51321/APP/2025/2991 - Haydon House, Joel Street - Design Comments

This revised proposal is broadly supported, subject to the following few queries / comments below.

PROPOSED FRONT ELEVATION

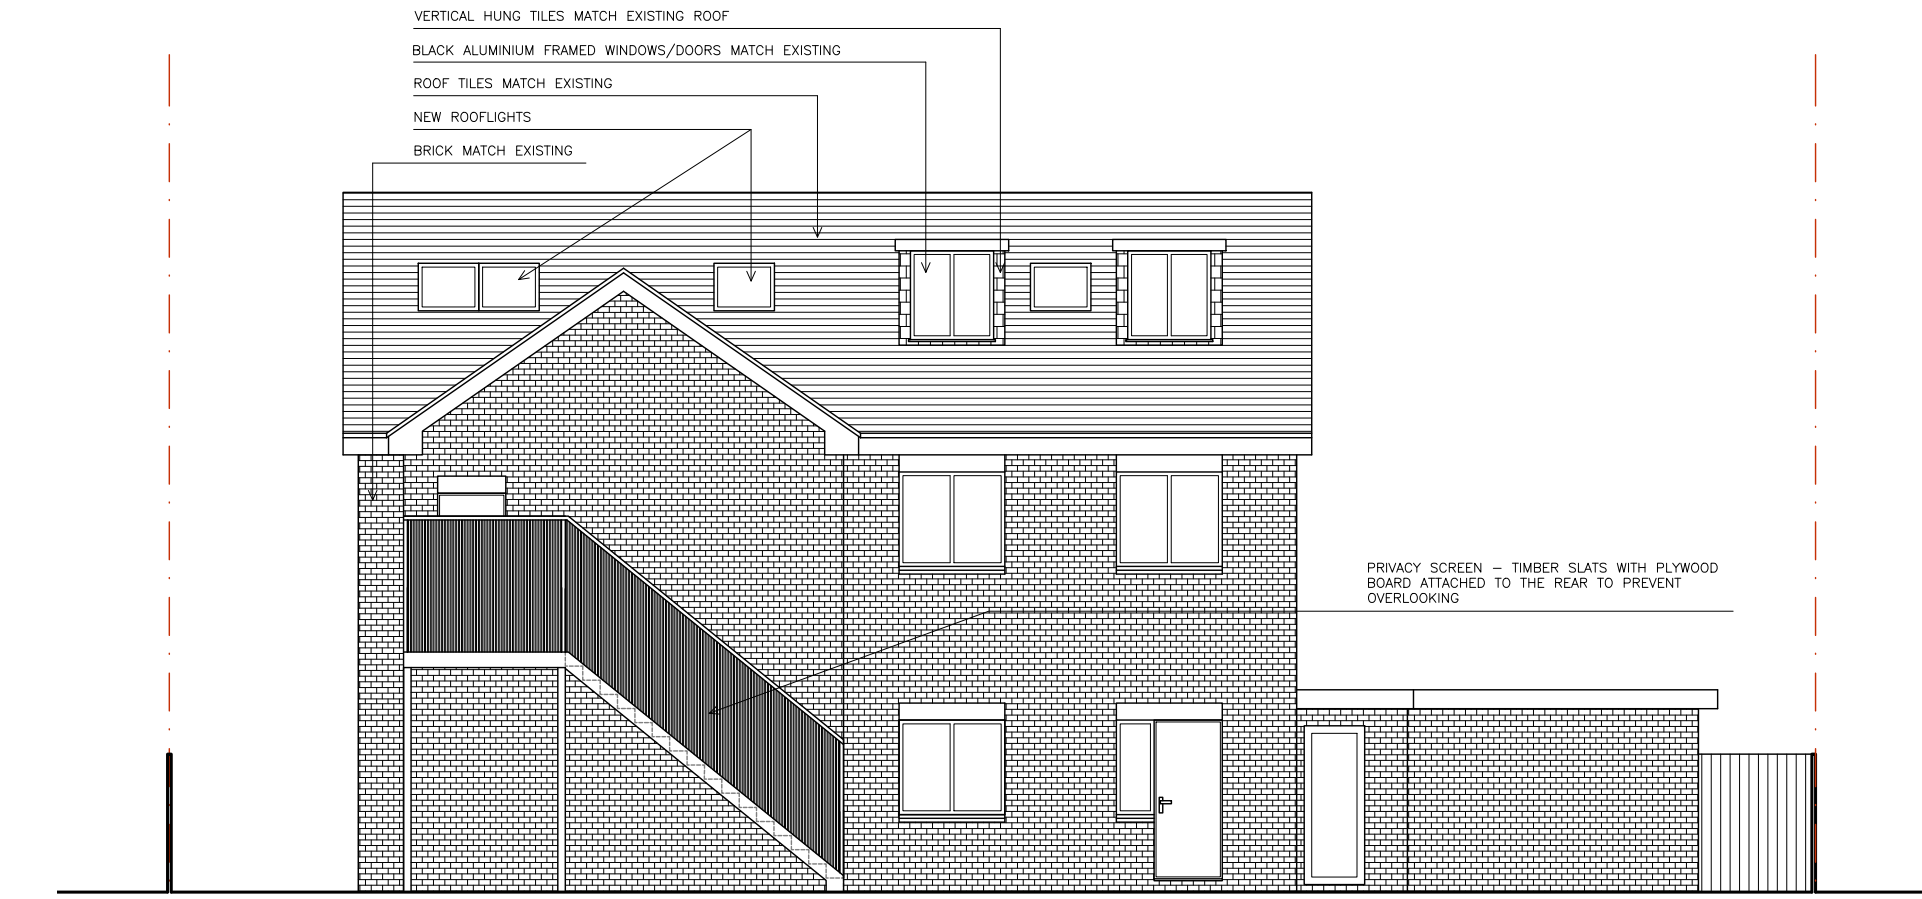
In comparison to the previous iteration, this revised scheme proposes an acceptable appearance for the front of the building.

The removal of the top-floor balcony is supported as it resolves previous concerns.

The chamfered corners remain a minor concern but can be managed via detailed design / condition discharge (e.g. conditioning soffit design).
